**Your Ref:** OWPC25520  
**Our Ref:** EP/160/19/PL 04-12-2019  
**Please ask for:**  
Zac Denton

Demolish redundant external store and former outside toilet at rear of 43 Sea Road and construct a single storey extension to create a 2 bedroom apartment.

Land to the rear of 43 Sea Road East Preston

PROPOSED ELEVATIONS

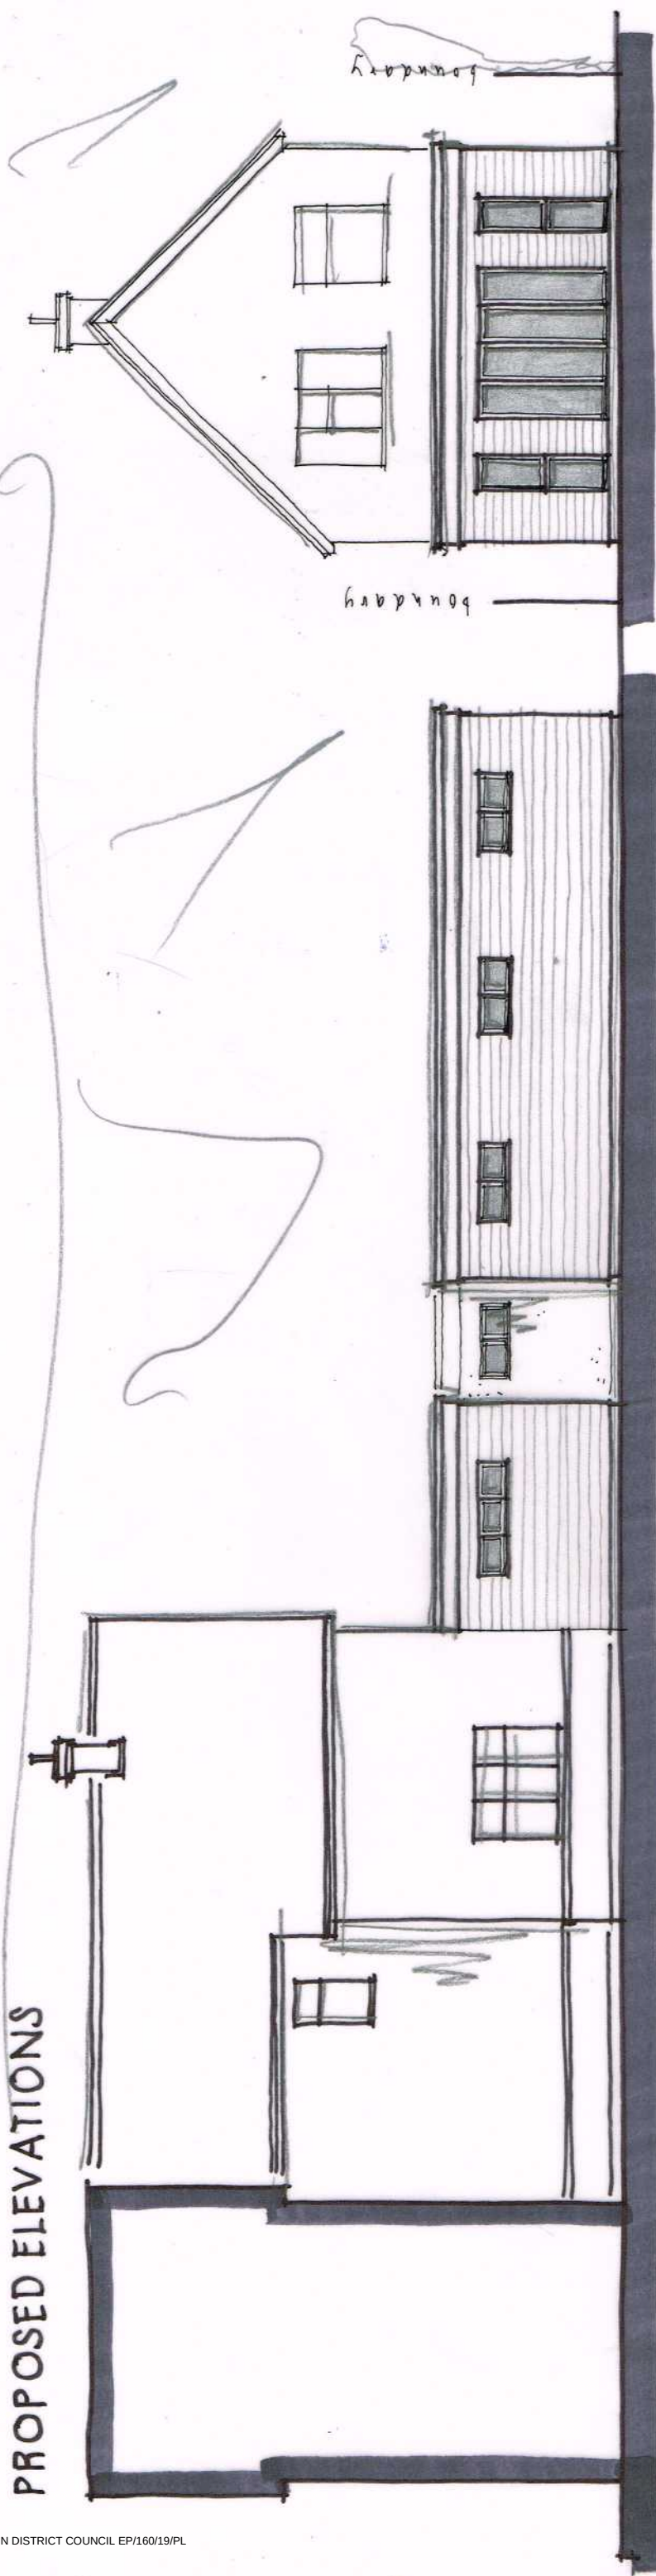
- 1. This building runs parallel to my property and extends 100% across the total width of our property. Currently it has open views across the existing garden area and beyond on both ground and first floor.*

- 2. the windows to both the kitchen and the lounge of the proposed building, although at high level, would overlook our kitchen, Lounge and 2 bedrooms. Not only views but light pollution.*

- 3. The proposed building is approx 1m from our garden boundary. It would be only be 8.5m from our living areas that have views from the ground floor that are currently enjoy green open space.*

- 4. From the first floor bedrooms which again look onto open green spaces would look onto an ash felted or similar flat roof expanse.*
  - 5. The application mentions this is a development of a 'brown field' site which I believe is misleading as it is currently a garden area.*
